CUMBERLAND
CITY COUNCIL

Our Ref: OA2021/0005
DPIE Ref: SSD-10399

Subject: Request for Comments - State Significant Development (SSD)
Application No: SSD-10399
Property: 44 Clunies Ross Street & Great Western Highway, PROSPECT NSW 2145
615A Great Western Highway & Boral House – Clunies Ross Street,
PEMWULWUY NSW 2145
Proposal: Proposed warehouse and logistics estate at Clunies Ross Street,
Pemulwuy

SOFTSCAPE

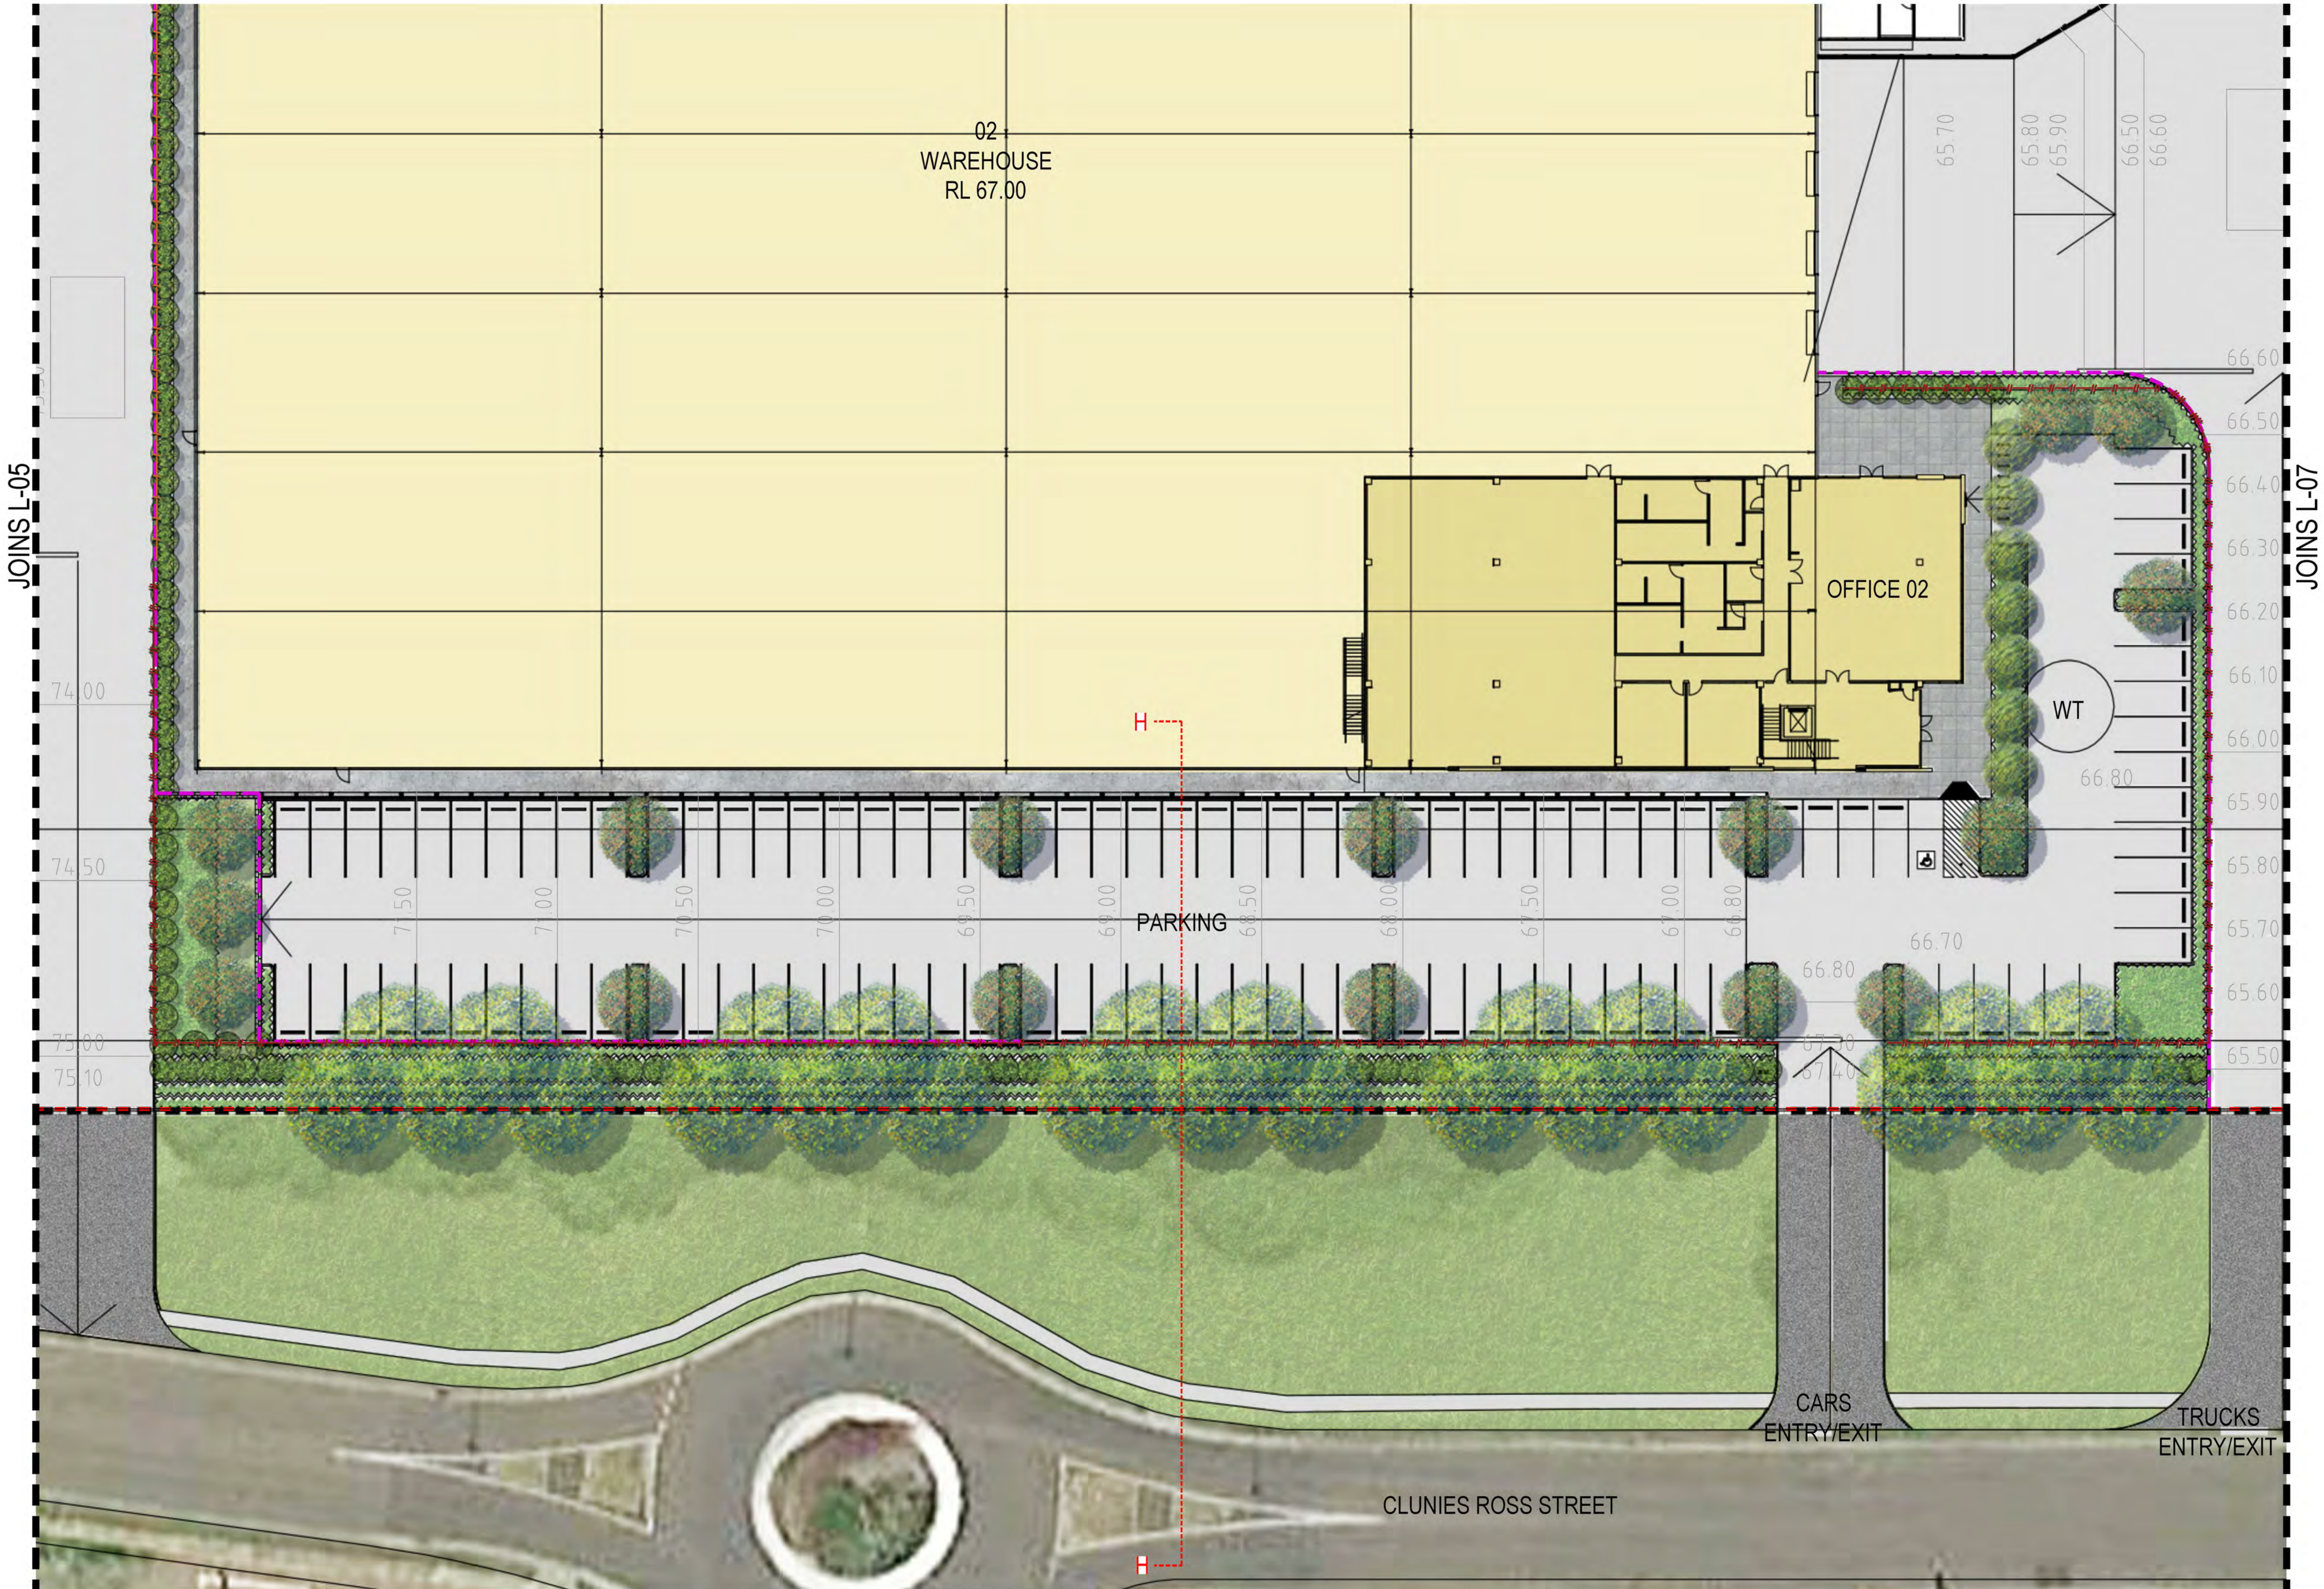
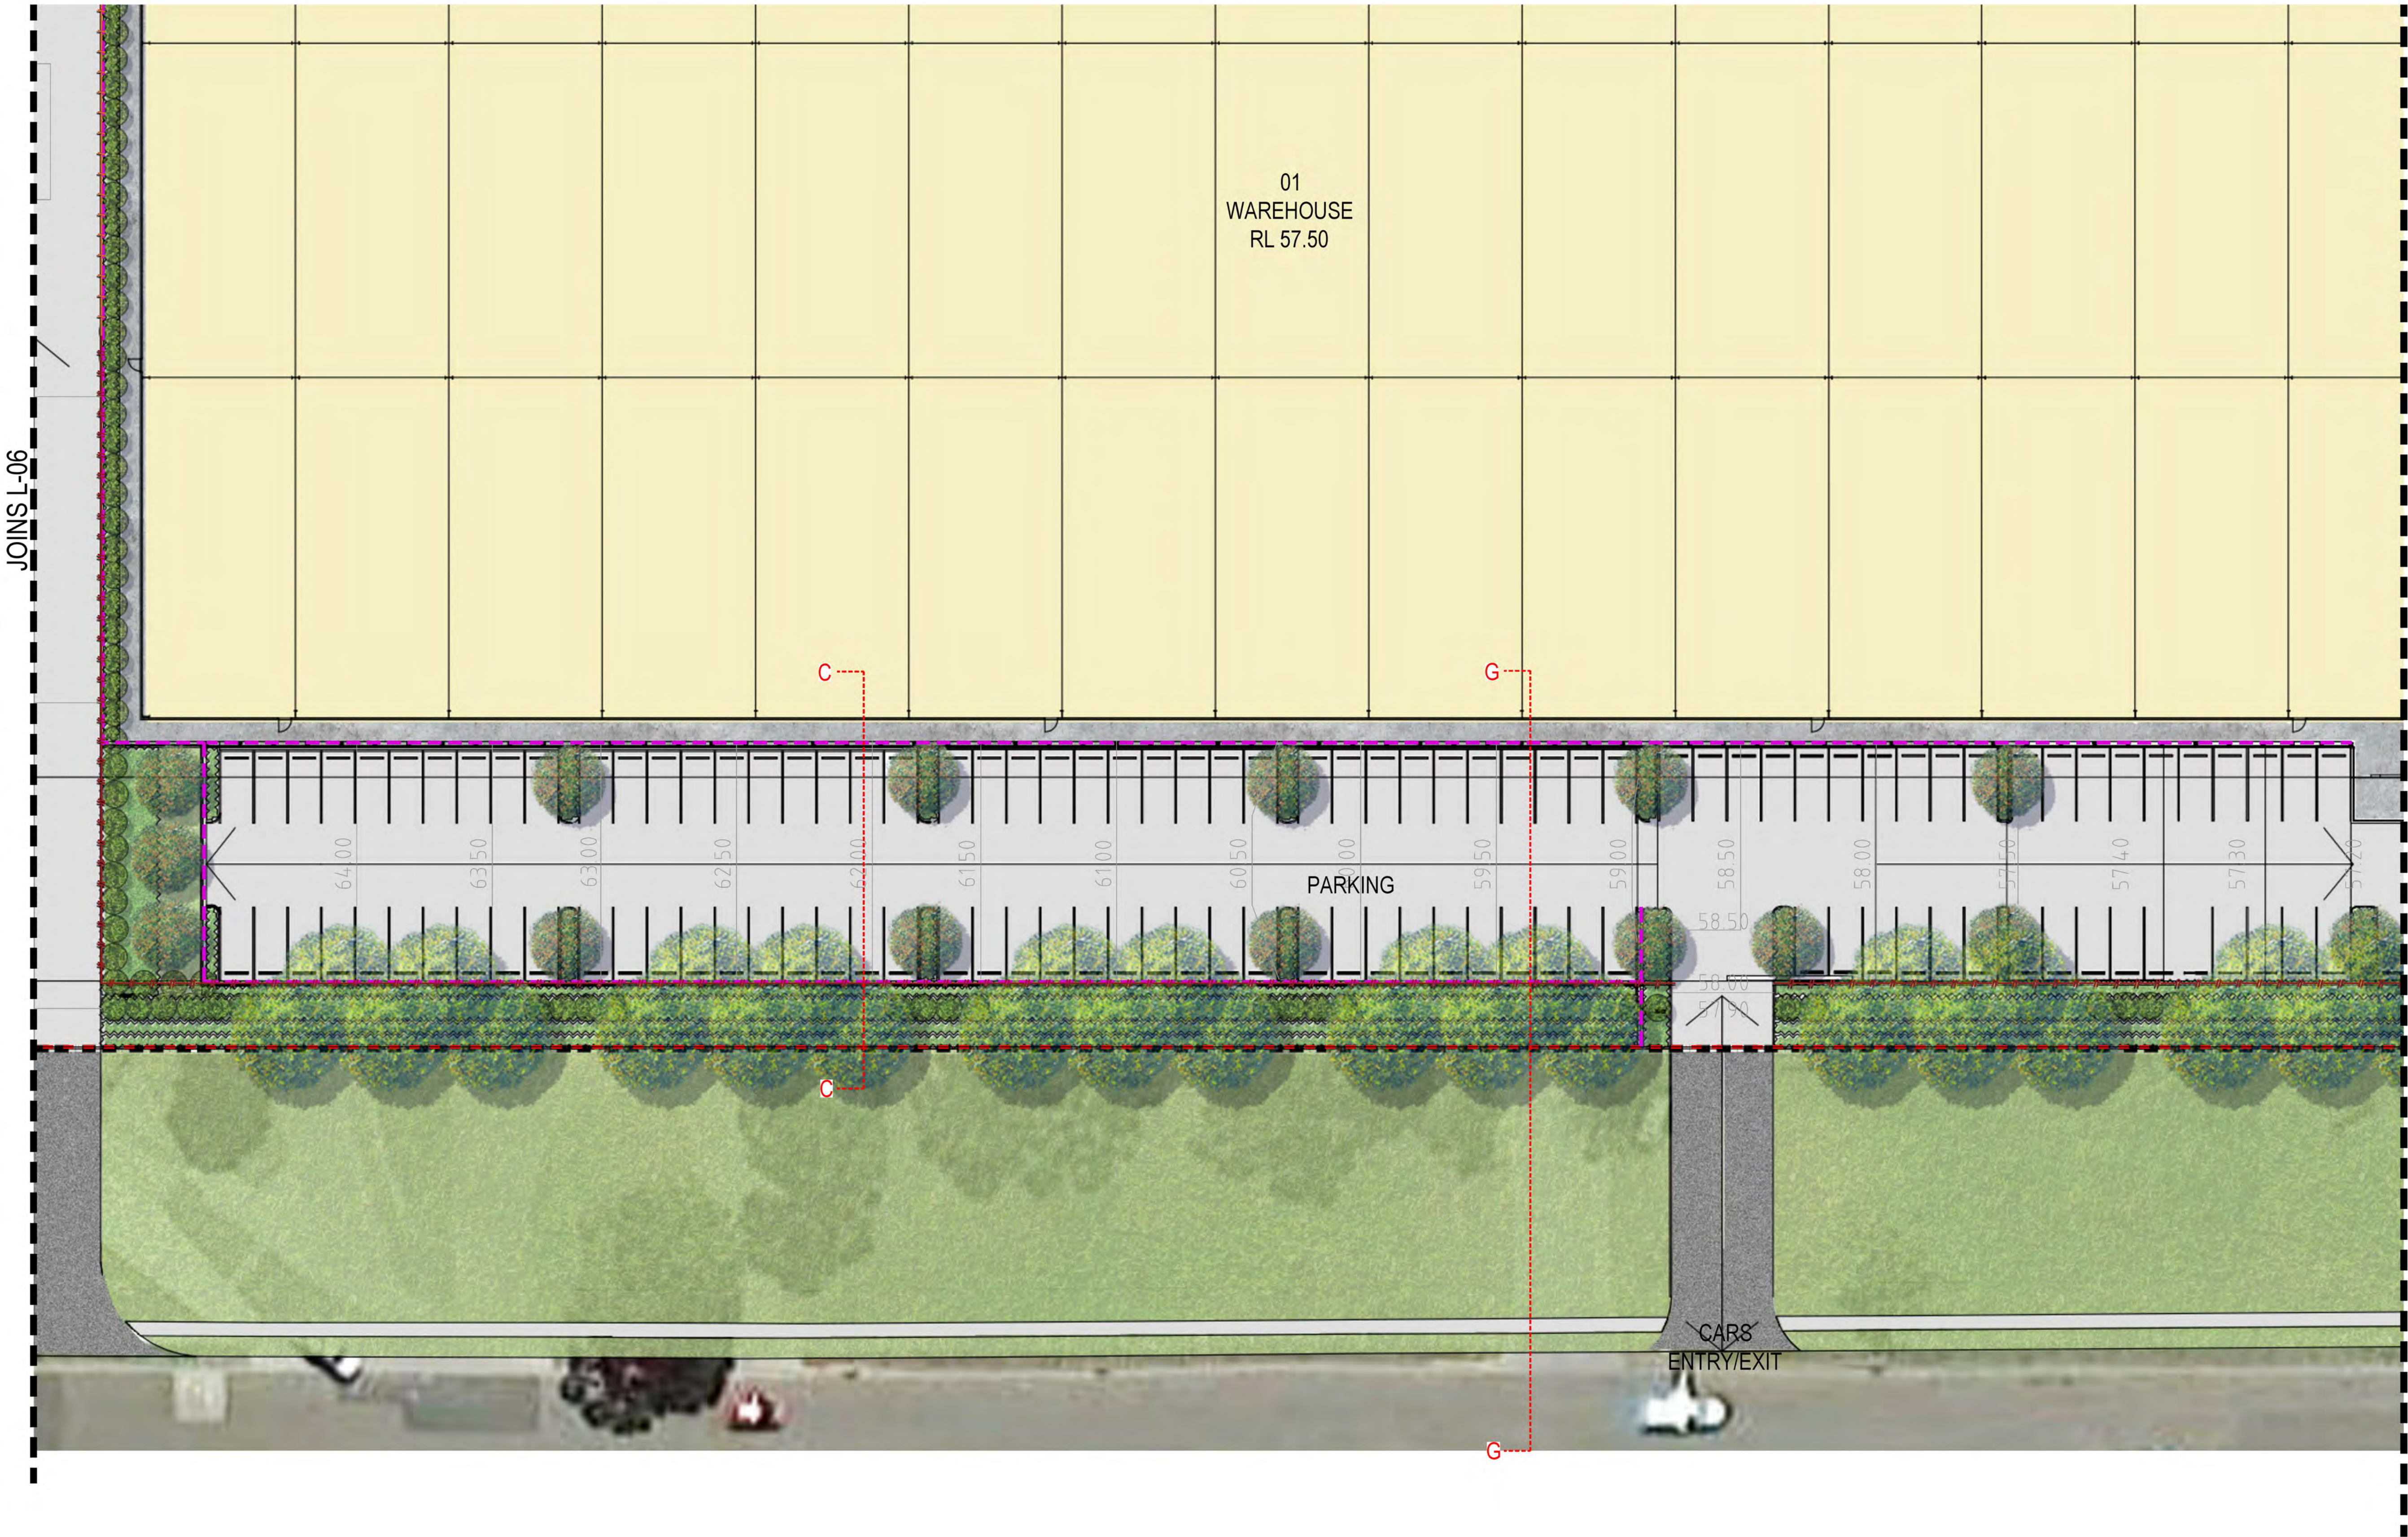
12. No detailed landscape plans have been submitted. Clarification is required in relation to the finished streetscape landscaping proposed along Clunies Ross Street and the treatments along the rear boundary perimeters especially the creek line areas, whether they will be revegetated with CPW Species, etc.
